SUBJECT: Engineering Review Comment
Mountain View Electric Association Inc. (MVEA)

Project Name: Waterbury Filing 1 – Final Plat

Project Number: SF237

Description: Proposed development of 198 residential lots and 11 tracts on approximately 62 acres located north of Stapleton Rd. between U.S. Highway 24 and Eastonville Rd. in Township 12S, Range 64W, Sections 28, 29 and 33.

DRAWN BY: JMT
 CHECKED BY: ERF

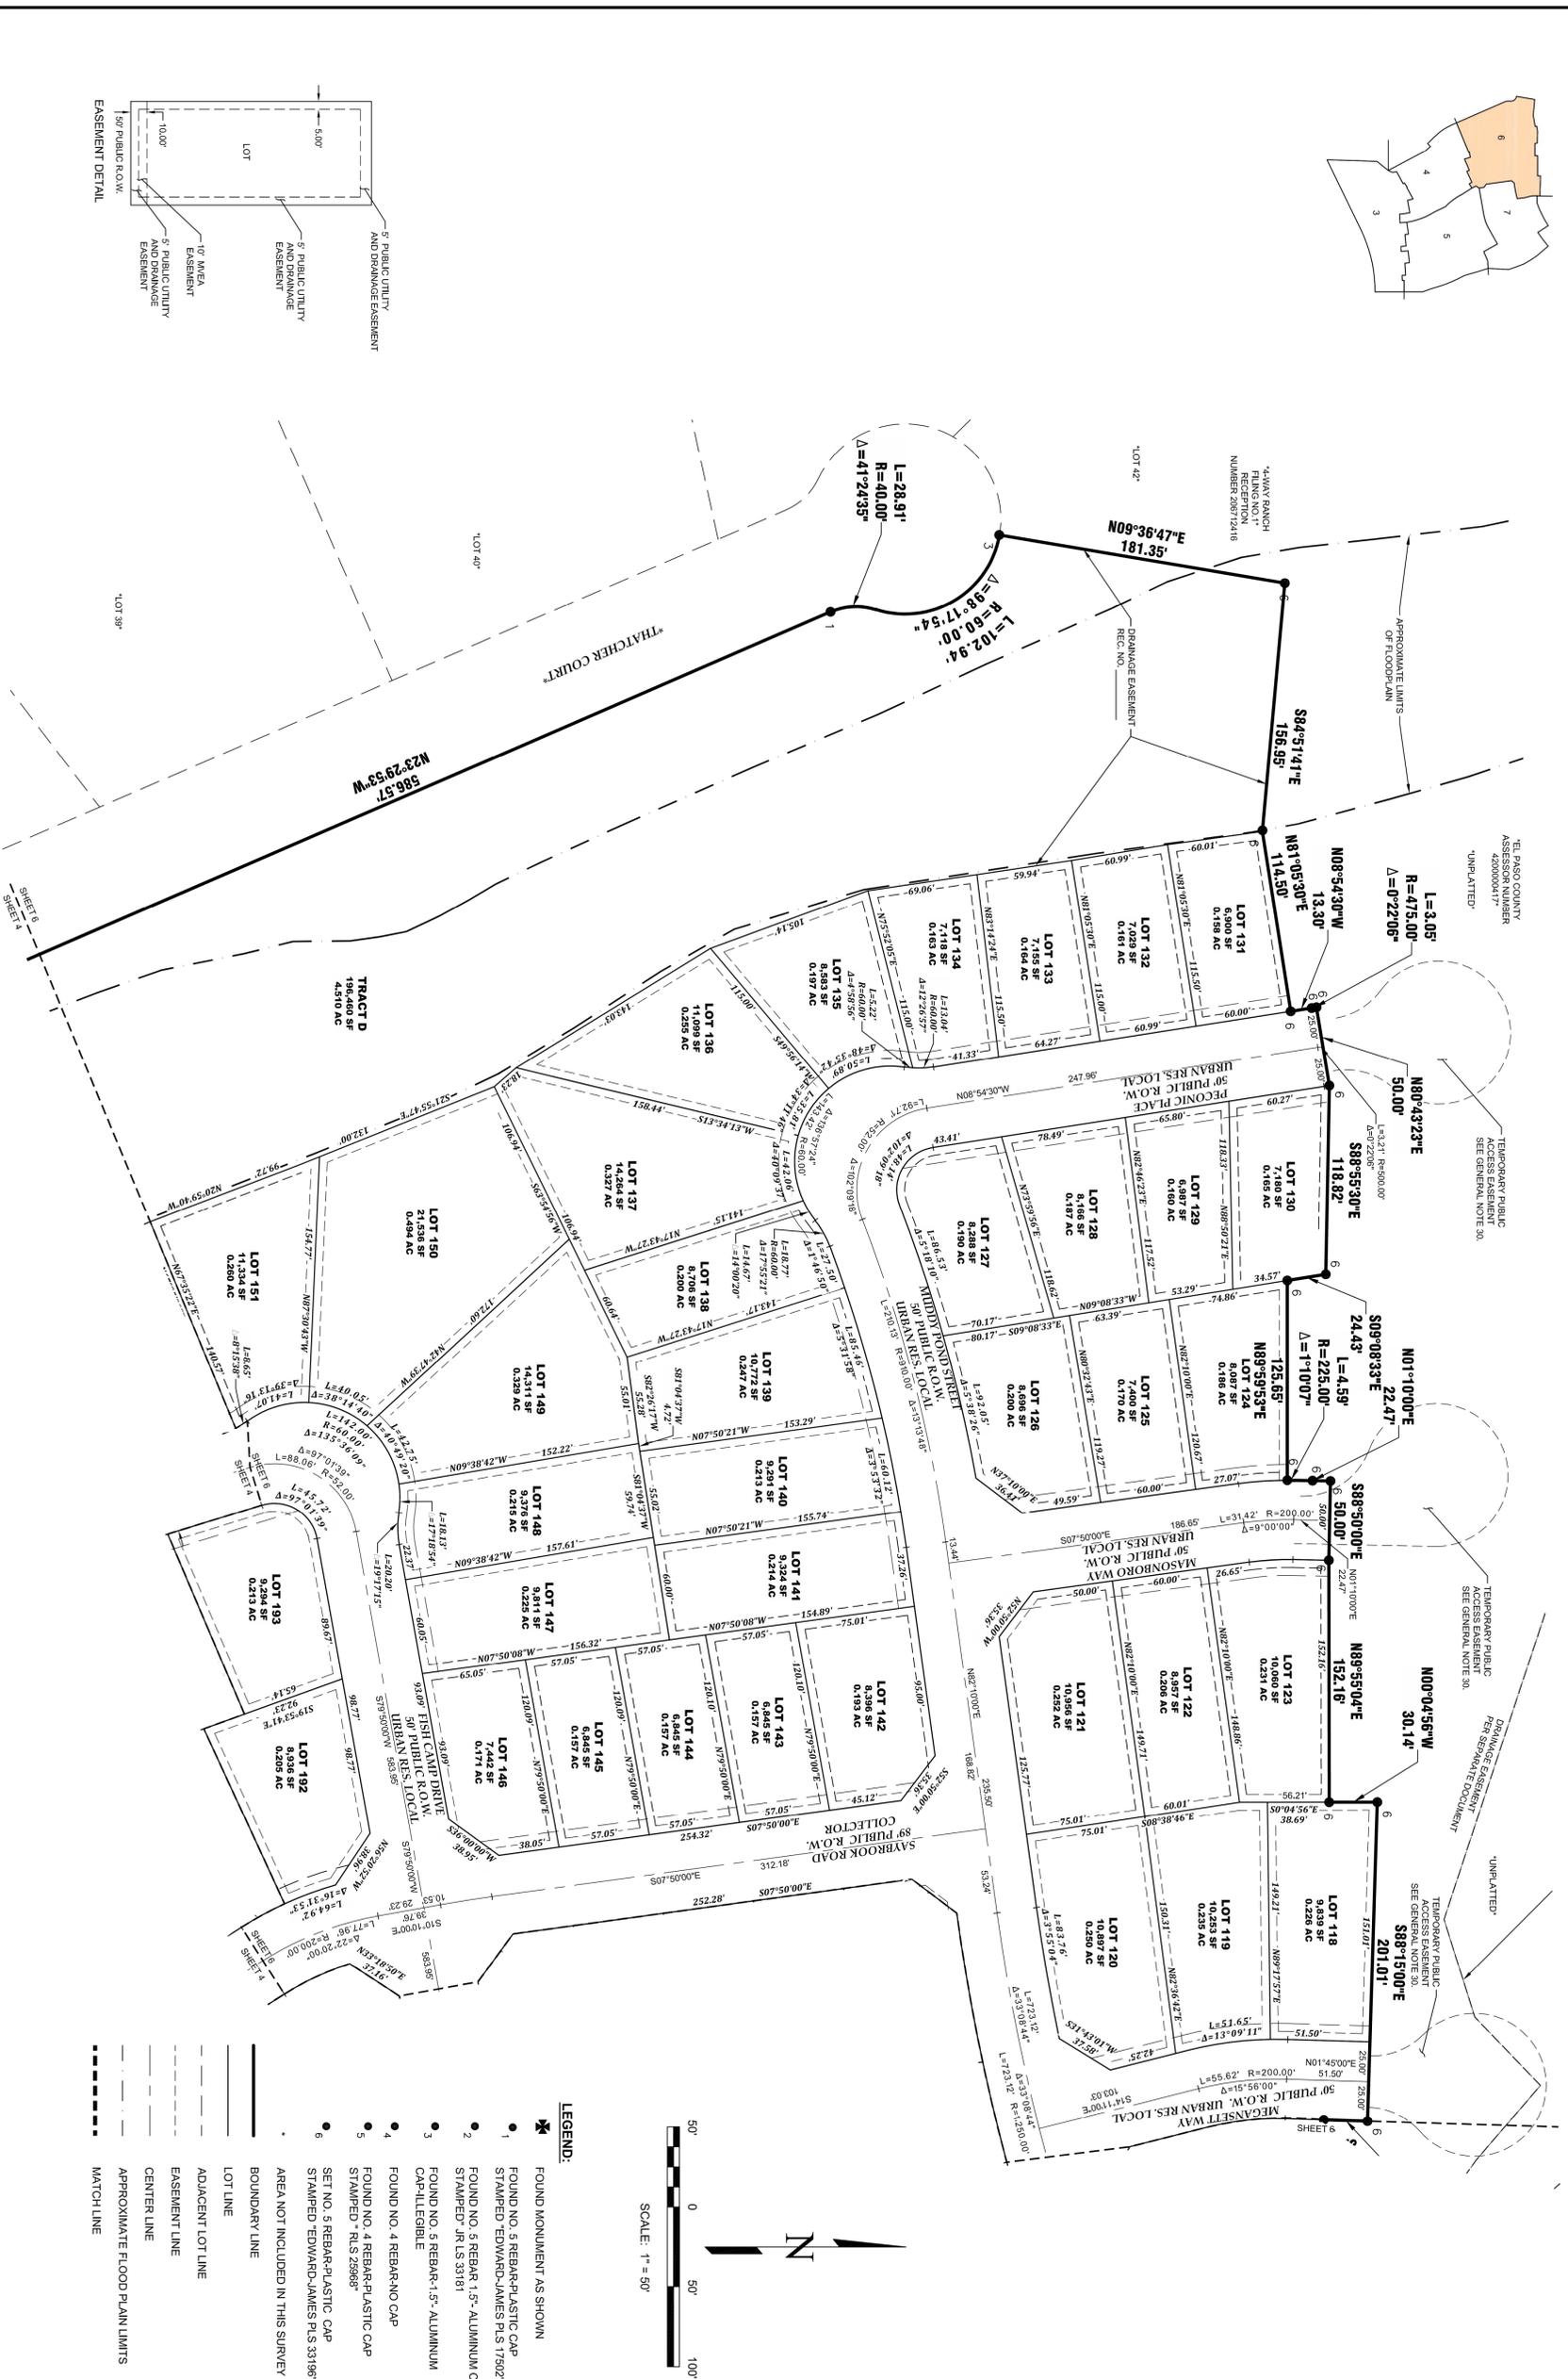
MVEA approves the ten (10) foot front lot utility easement in addition to any public improvement easements, as shown, and all tracts include easements. Please include "Utilities" under all tracts in the Tract Table. MVEA also requests the platting of MVEA's existing facilities with easements on the plat. Additional easements may be required.
